## DEPARTMENT OF PUBLIC WORKS

**TO:** All Staff  
**FROM:** Public Works Plan Review Team  
**DATE:** December 12, 2022  
**SUBJECT:** LPF-22-00008

SHEET 1 OF 2

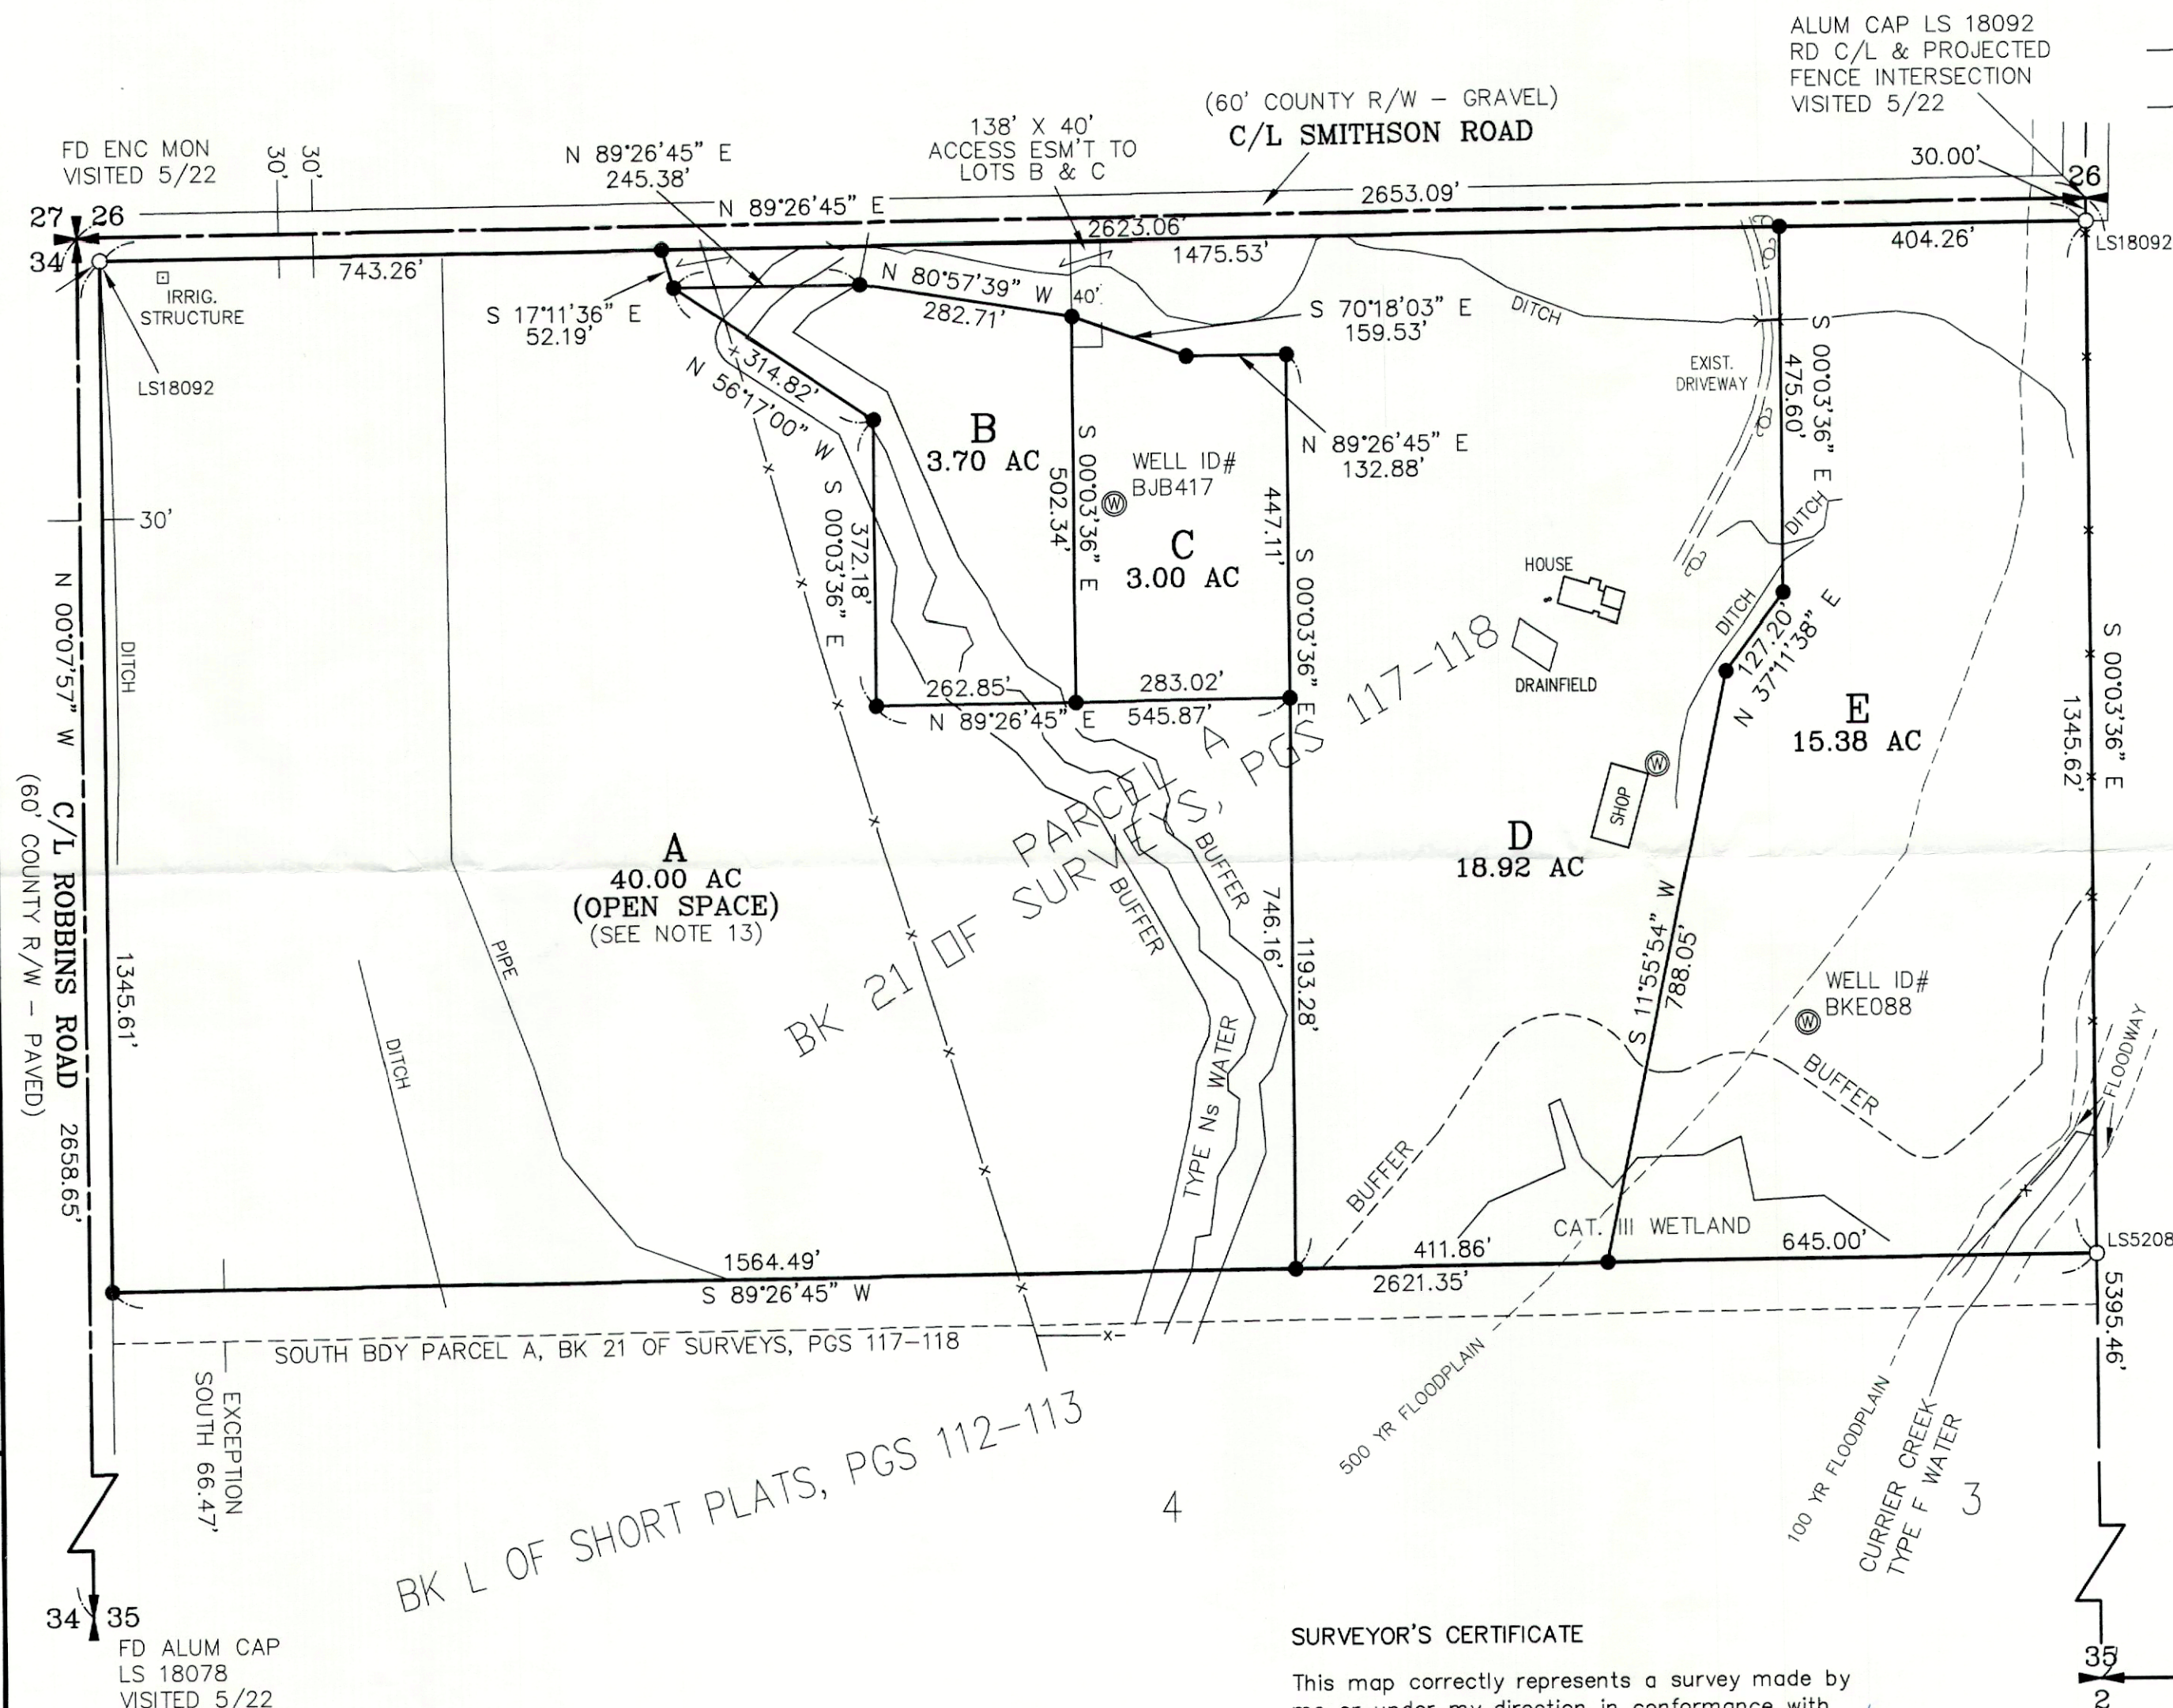
<b>ACCESS</b>	Access easement for Lots B & C is not fully shown. The eastern line is missing south of the ditch line and begins again at Lot C.
<b>ENGINEERING</b>	No further comment
<b>SURVEY</b>	No further comment
<b>FLOOD</b>	No further comments- KCC 14.08 requirements have been met for final plat approval.
<b>WATER MITIGATION/ METERING</b>	No further comments- water mitigation/metering requirements for final plat have been met.
